DECISION NOTICE

Application Ref: AB/2/18/HH

22 Park Place
Arundel
BN18 9BE

Replacement of 9 No. casement windows with new casements & sliding sashes & insertion of a new door opening to the east elevation (resubmission following AB/158/14/HH). This application affects the character & appearance of the Arundel Conservation Area.

WEST ELEVATION

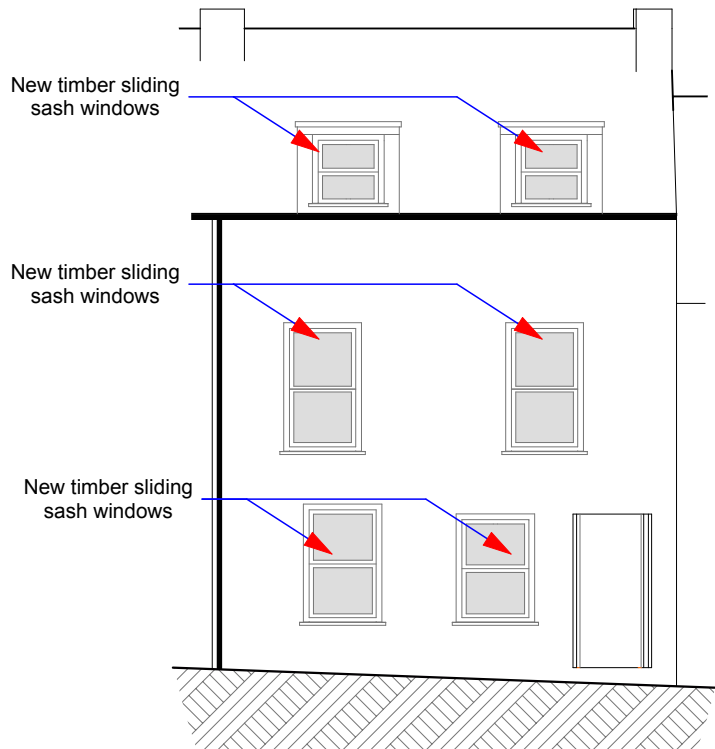
If the application is approved the style and manner of glazing should be reserved by condition. To West Elevation, the sashes should be in the same plane as existing, white painted softwood and single glazed, vertical sliding sashes. It is suggested that windows from another property in the range be copied (rails, glazing bars, horns etc), to ensure visual harmony.

- 3 No development shall commence unless and until details including cross sectional drawings, materials and colours to be used in the replacement windows and new door hereby approved have been submitted to and approved by the Local Planning Authority and the details so approved shall be used in their construction and retained thereafter.

EAST ELEVATION

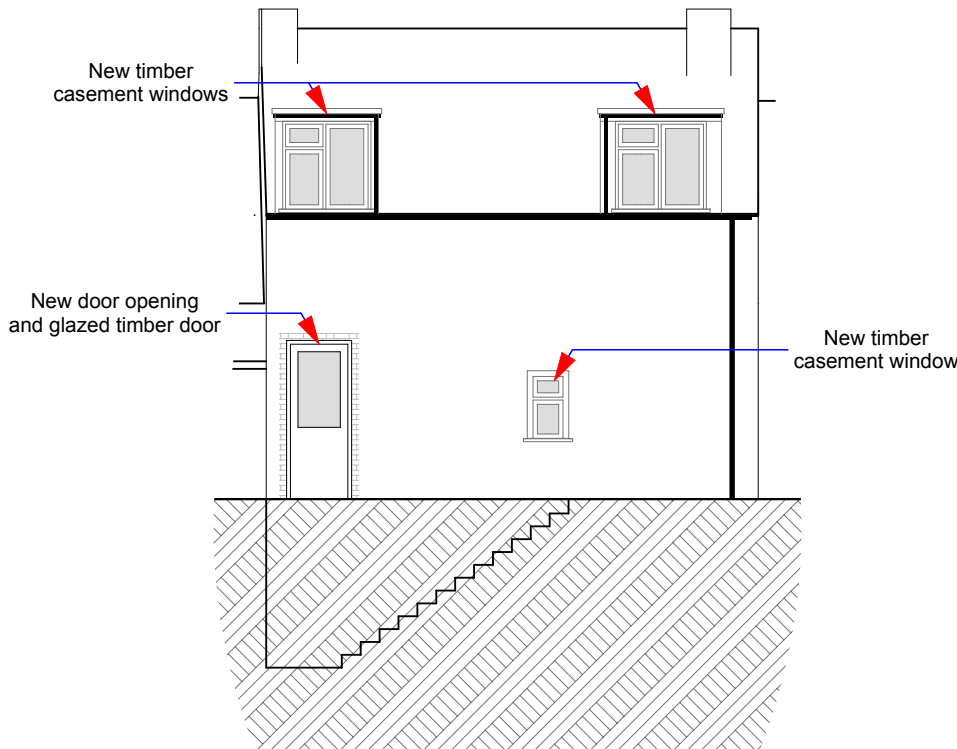
Timber casements to East Elevation should be replicated as existing in white painted hardwood, single glazed. The door style should also be reserved by condition, as there is insufficient detail at a scale of 1:100 to provide comment, although the insertion of a door at this point is supported.
